OFFICE WAREHOUSE DEVELOPMENT PLAN MINOR AMMENDMENT

9495 PEACEFUL VALLEY ROAD COLORADO SPRINGS, COLORADO 80925

Floor Plans_v1.pdf Markup Summary

John P. **nelson** associates
1626 E. Pike Peak, Colorado Springs, CO 80909 Phone: (719) 632-3384
John@jpnarch.com (719) 632-1781 fax
SITE /LANDSCAPE PLAN

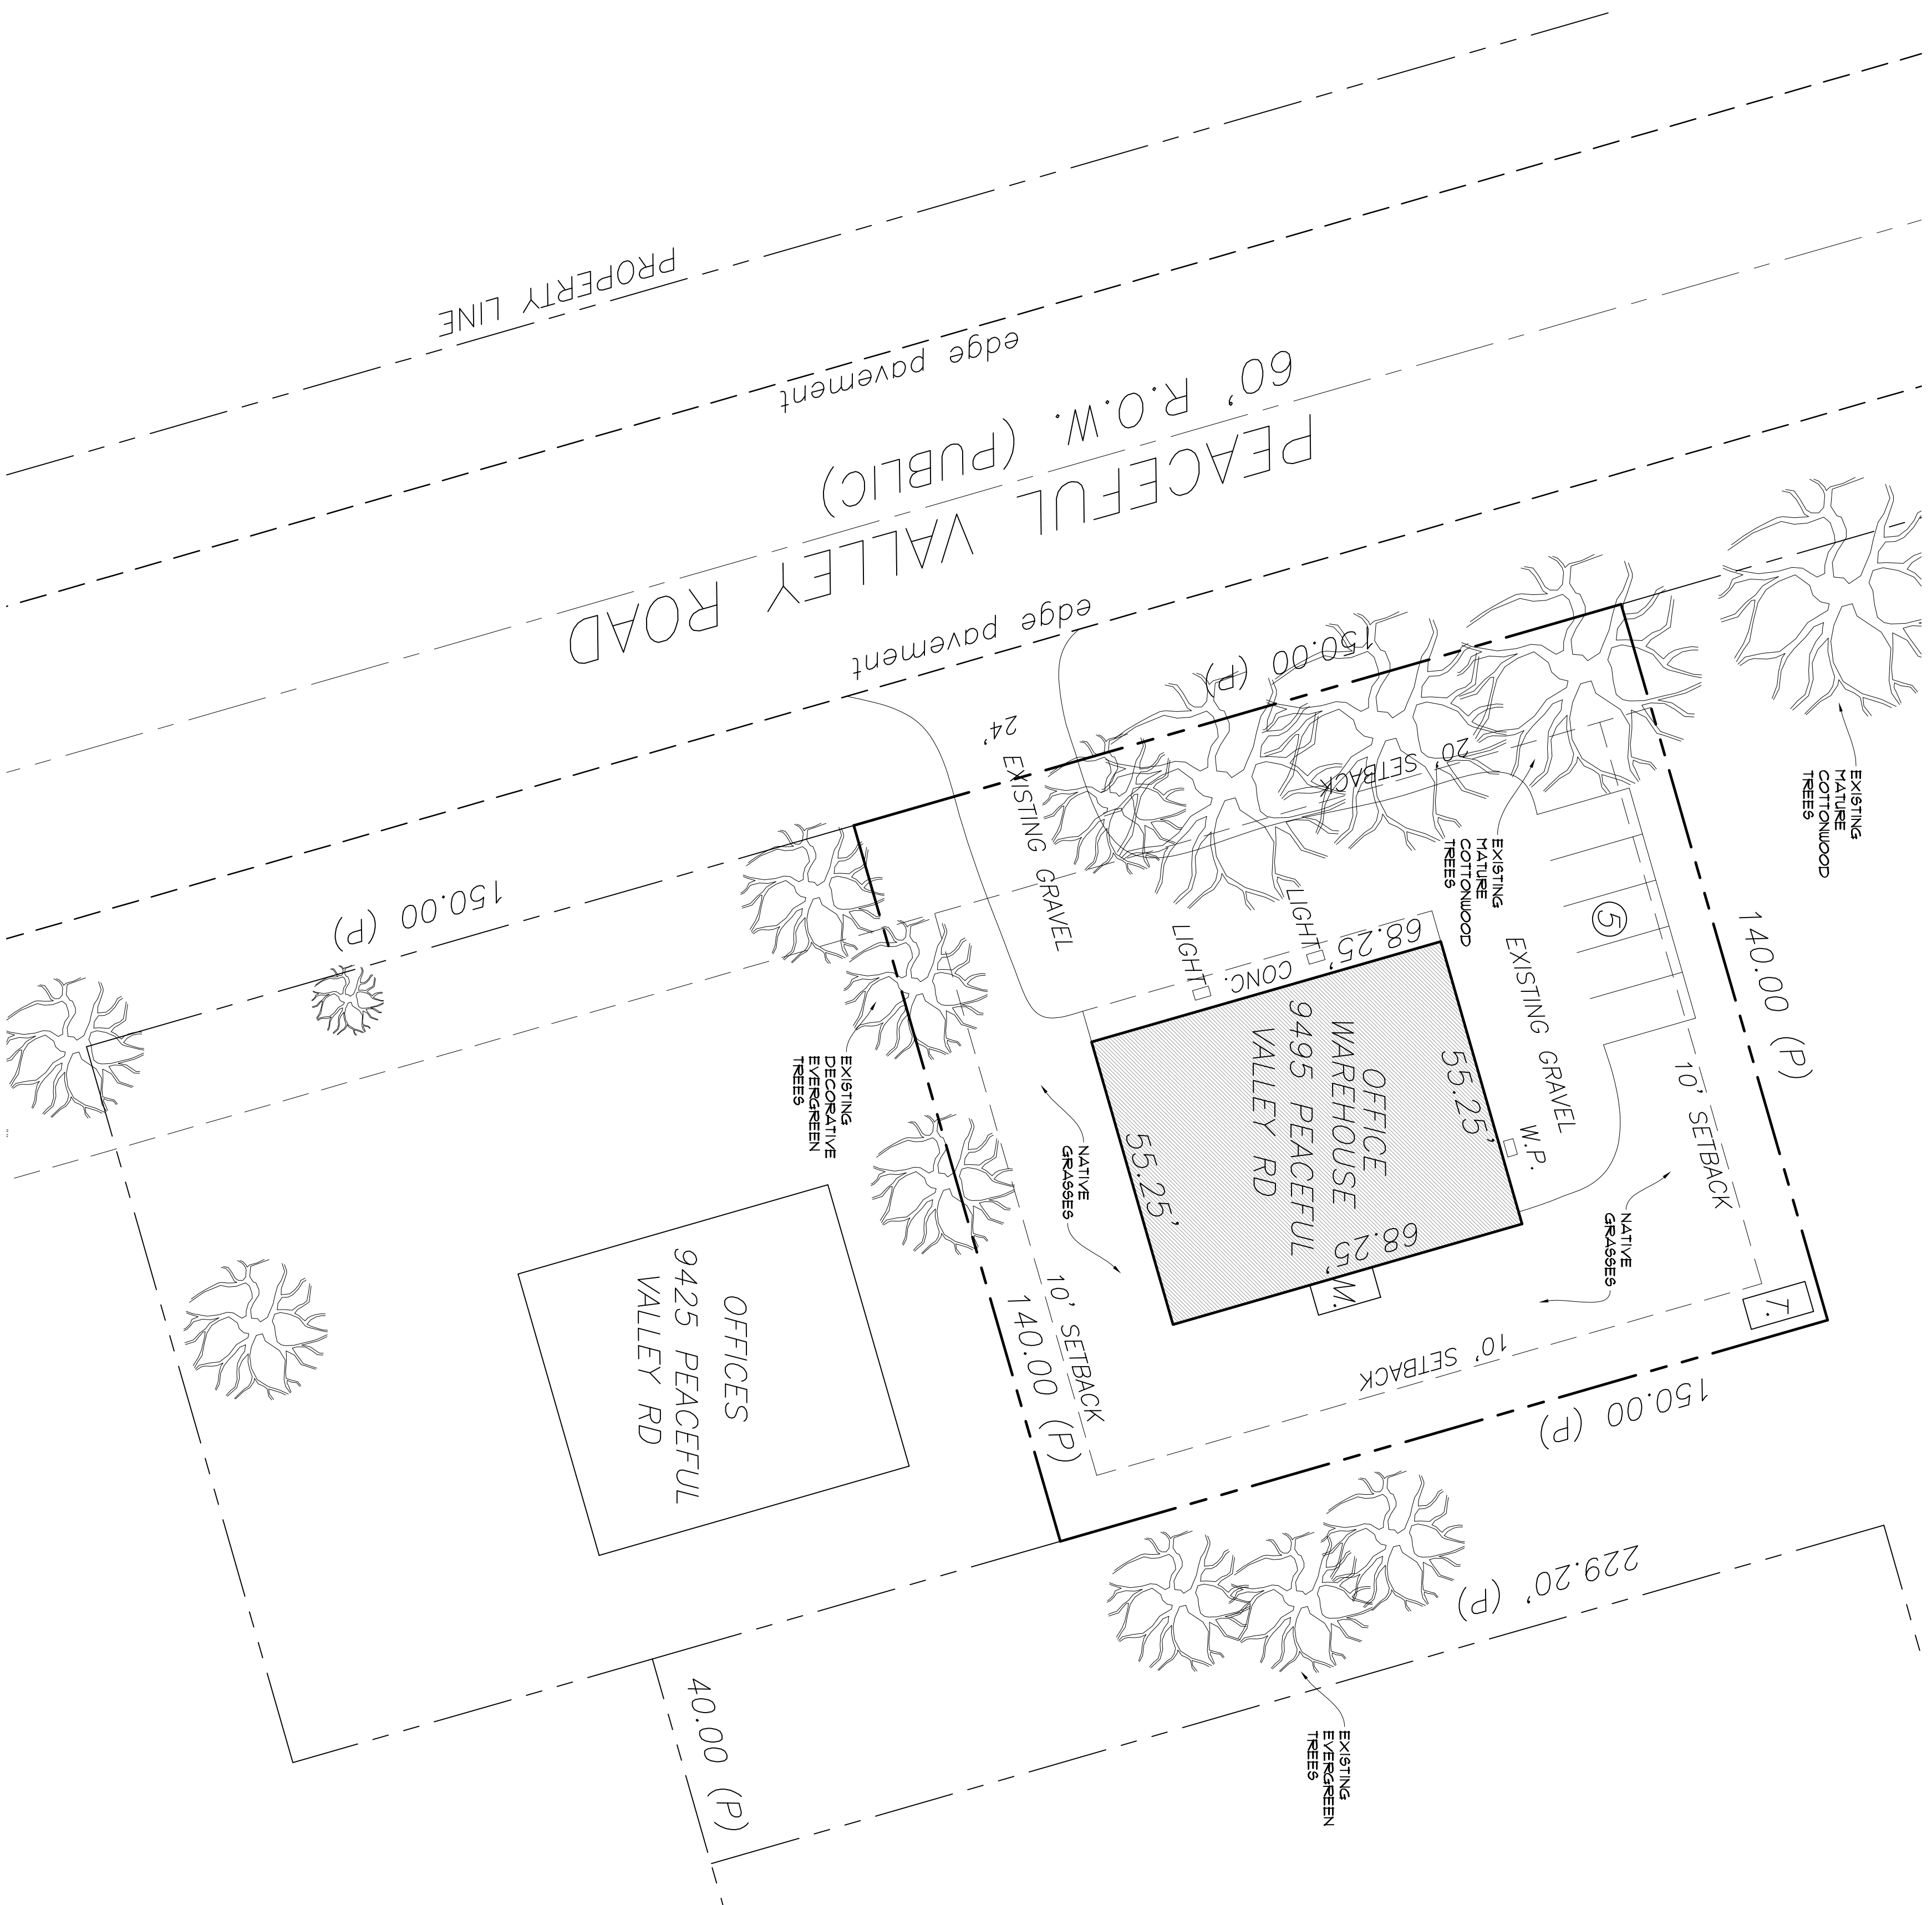
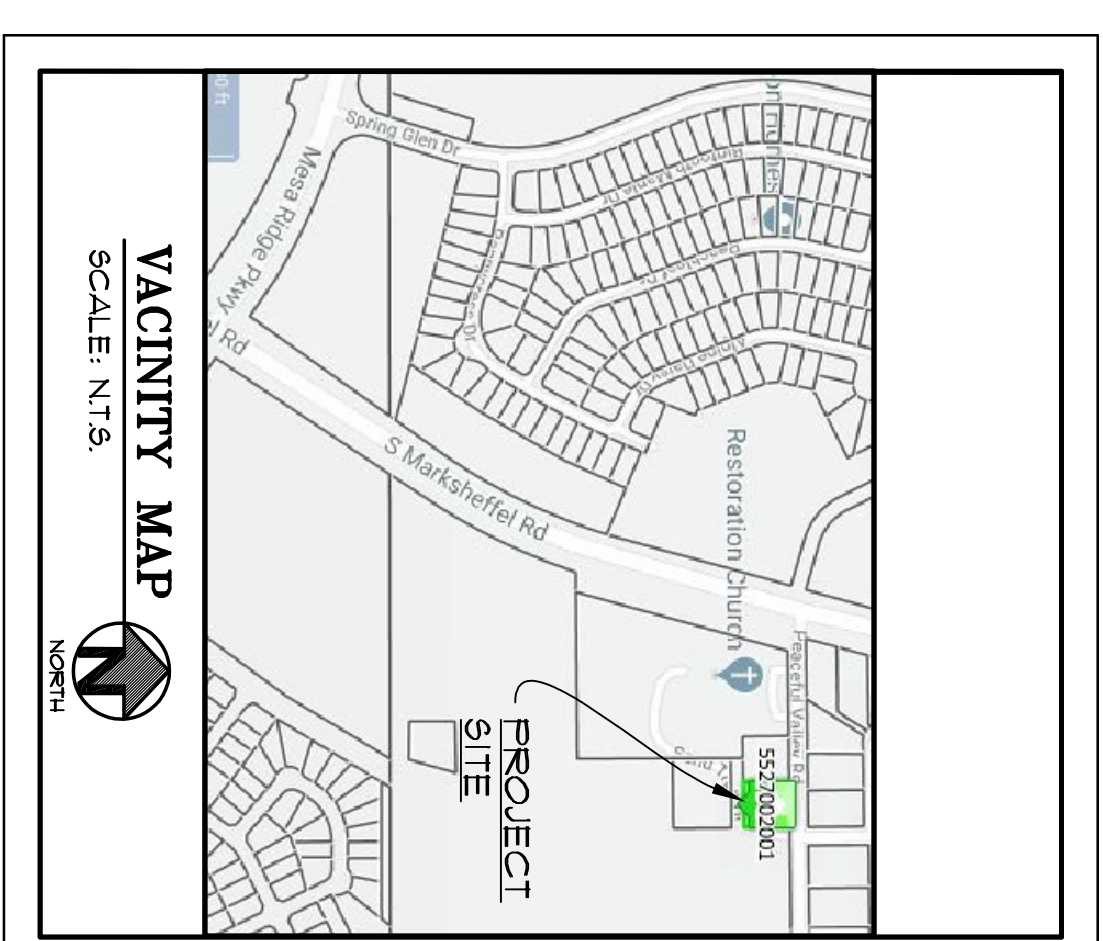
Add PCD File # to all pages

Floor plans are required to show uses inside of building in order to review parking detail against uses
